Jeanie Bourke - RE: FW: Northeast Air single sheet pdfs

From: Mike Hays <mike@GRANTHAYS.COM>
To: Jeanie Bourke <JMB@portlandmaine.gov>
Date: 2/19/2016 12:59 PM
Subject: RE: FW: Northeast Air single sheet pdfs
Attachments: A0 COVER SHEET.pdf; A1 PHASING FLOOR PLAN.pdf; A2 PHASE I FLOOR PLAN.pdf; A3 PHASE I FINISHES PLAN.pdf; A4 PHASE I REFLECTED CEILING PLAN.pdf; A5 PHASE I FURNITURE PLAN.pdf; A6 PHASE I ROOF PLAN.pdf; A7 PHASE I EXTERIOR ELEVATIONS.pdf; A8 PHASE II EXTERIOR ELEVATIONS.pdf; A9 PHASE I BUILDING SECTION.pdf; A10 PHASE I VESTIBULE & CANOPY SECTIONS.pdf; A11 PHASE I BUILDING SECTION.pdf; A12 PHASE I BUILDING SECTIONS.pdf; A13 PHASE I DOORS.pdf; A14 PHASE I WINDOWS.pdf; A15 PHASE I DETAILS.pdf; A16 PHASE I DETAILS.pdf; A17 PHASE I INTERIOR ELEVATIONS.pdf; A18 PHASE I INTERIOR ELEVATION.pdf; A19 PHASE I DETAILS.pdf; A20 ACCESSIBILITY DETAILS & NOTES.pdf; AD1 DEMOLITION FLOOR PLAN.pdf; AD2 DEMOLITION ELEVATIONS.pdf

AD1

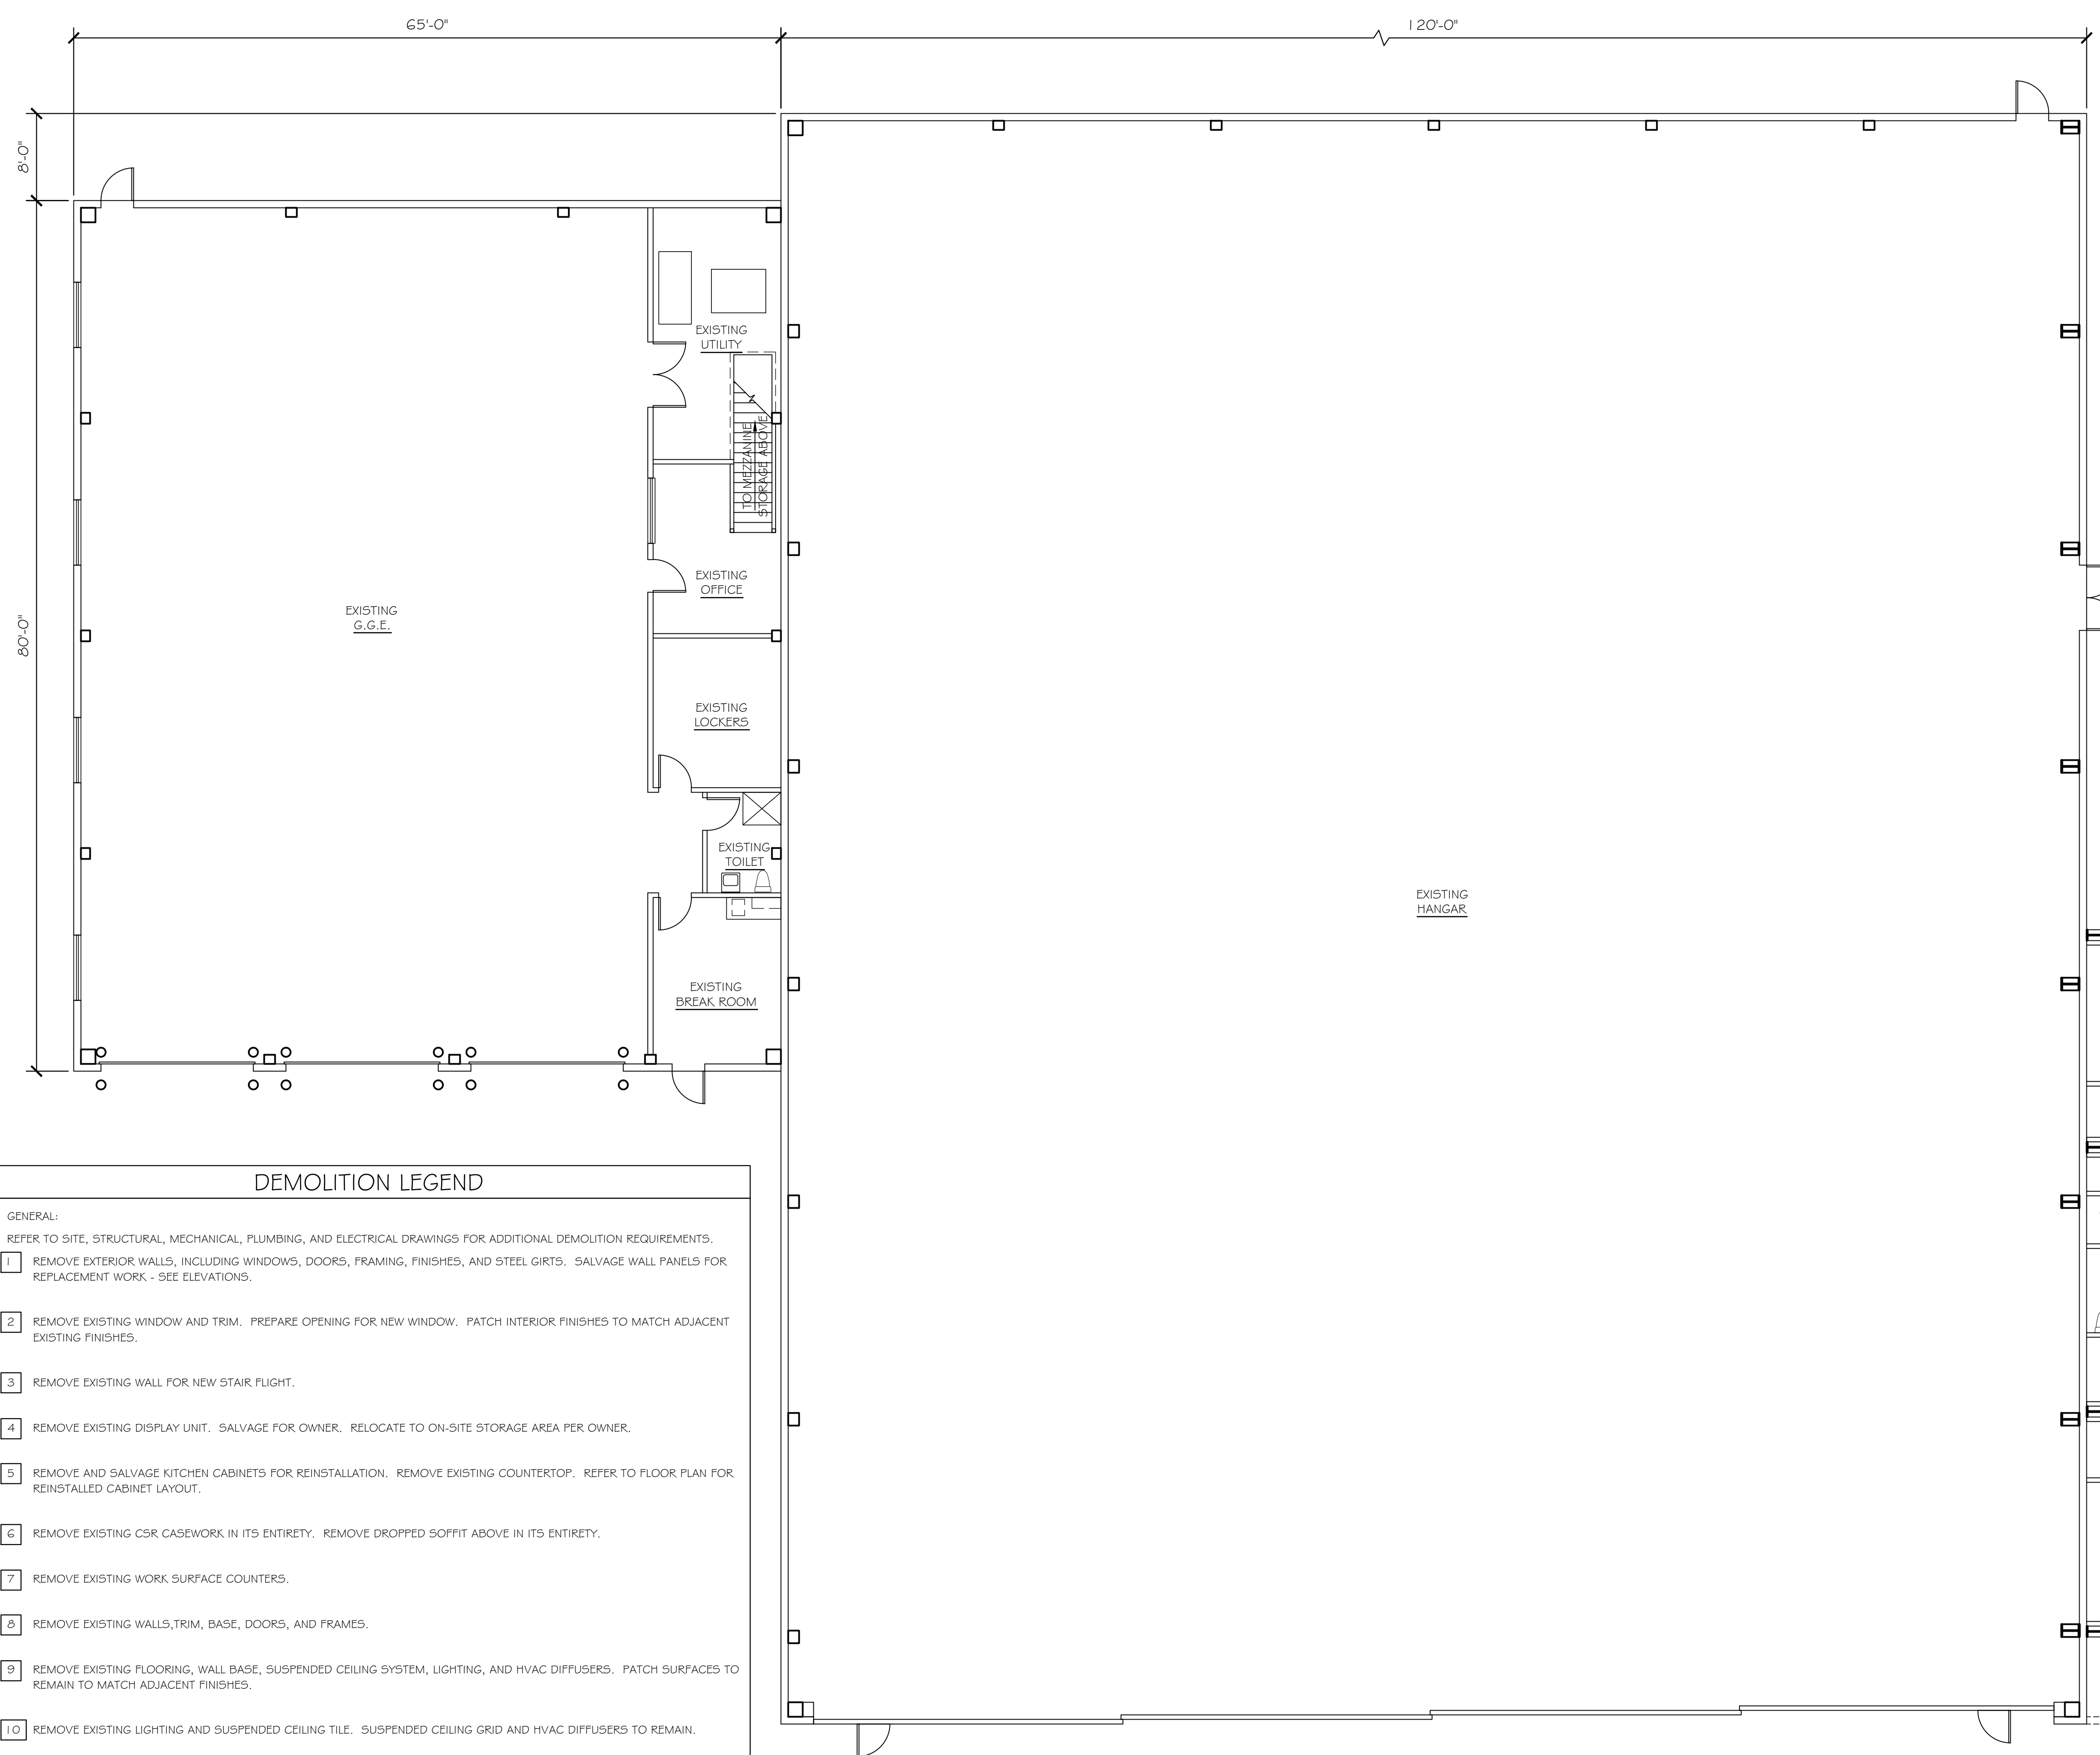
Mike, in this case only, KD wood for the stair extension will be allowed as it looks like the closet and the underside of the stair will be rated, per Sec. 603.1.11.

The existing stair is wood-framed. We designed the extension of that stair to match for ease of anchoring to the mid-level platform.

Thanks Jeanie – it will also be sprinkled above and in the closet below.
